4 April 2022

Our ref: 2200737
DPE Reference: SSD-7664-Mod-3

RE: Horsley Drive Business Park – Stage 2 – Mod 3 (SSD-7664-Mod-3) – Response to Request for Additional Information

Figure 2a. Plan of Subdivision, Drawing No. 10990-002 Rev D - Sheet 1, prepared by Shawn Leclerc and dated 26 April 2022

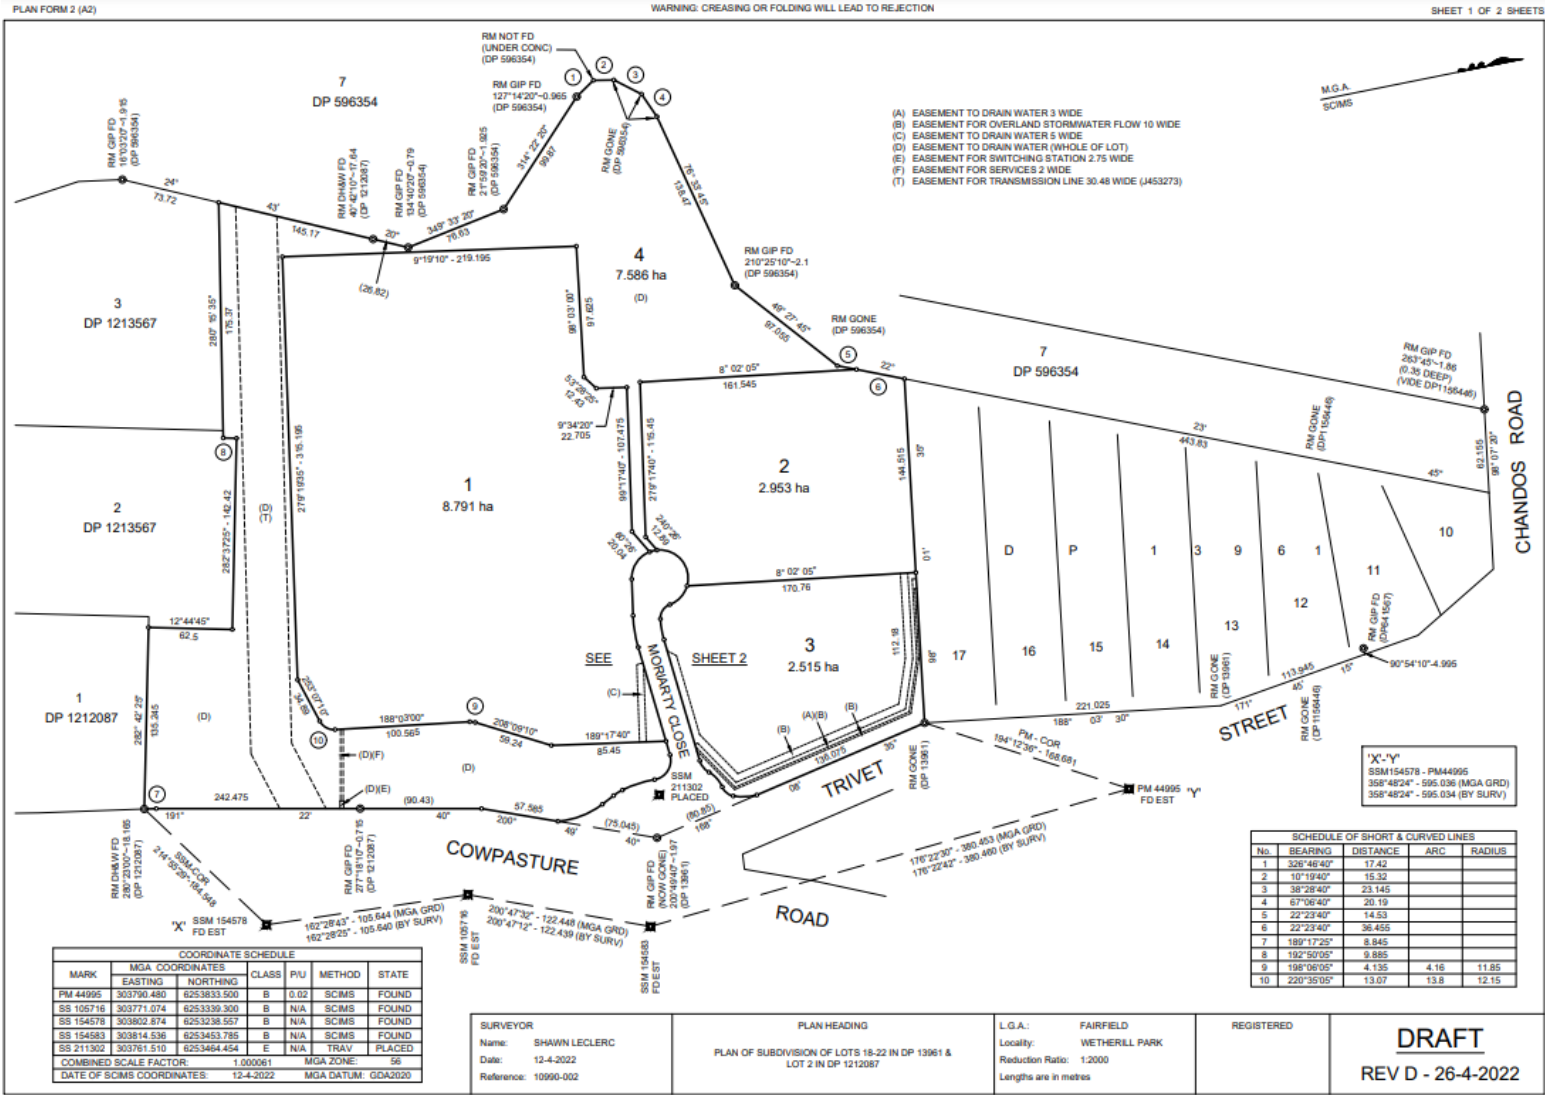
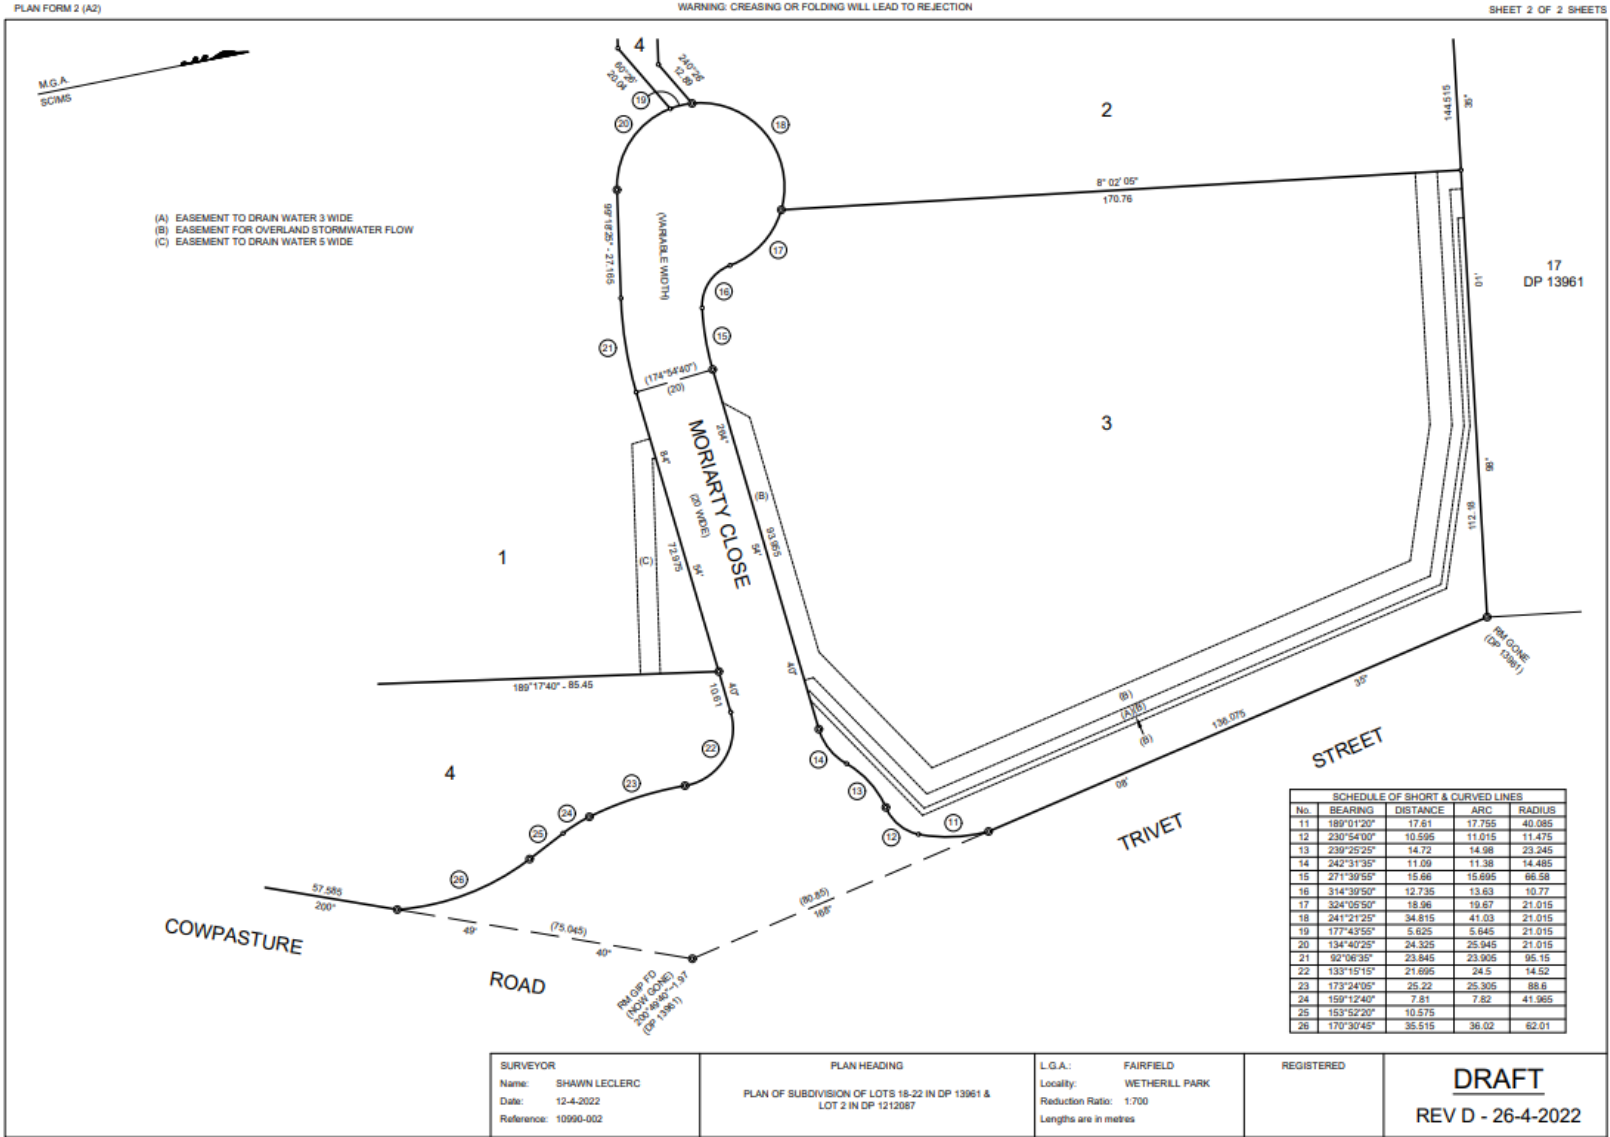
- *The proposed lot size changes between the approved and proposed Lot 2 results in a gain of 0.245 ha whereas proposed Lot 3 results in a loss of 0.248 ha. Could you please clarify the exact extent of the proposed changes between Lots 2 and 3?*

It is recognised that proposed northern Lots 2 and 3 were approved under SSD-7664 with lot areas of 2.709 ha and 2.763 ha respectively (TOTAL – 5.472).

As per proposed plan of subdivision submitted with Mod 3, the Applicant is now seeking approval for Lot 2 – 2.954ha and Lot 3 – 2.515ha (TOTAL – 5.469).

The proposed changes between Lot 2 and 3, subject to approval under SSD 7664 Mod 3, has resulted from the boundary between the two lots (inter lot boundary running north south) shifting to the east in response to design progression of the two buildings.

The overall site area has changed by 0.003ha or 30m². The change to total site area is due to the previous subdivision plan being based on the title information however since the Concept Approval, Charter Hall has engaged a new surveyor and a boundary establishment survey was conducted on-site when construction commended for the early works approved under SSD-7664.

The boundary establishment survey found a discrepancy between title information and the actual survey. When the new surveyor went out to do the new establishment of boundary survey, they found some additional property boundary marks that made some changes to the Trivet Street boundary frontage. A discrepancy of this nature is quite common, particularly for older titles (which would have been completed with less advanced survey equipment) and for large parcels of land (where small errors and inaccuracies tend to multiply over large distances).

The above has resulted in a slight amendment to the northern boundary alignment and revision of the overall estate area of 30m² from that previously approved under plan of subdivision with SSD 7764.

Based on the above, the Applicant is now seeking approval for Lot 2 – 2.954ha and Lot 3 – 2.515ha (TOTAL – 5.469).
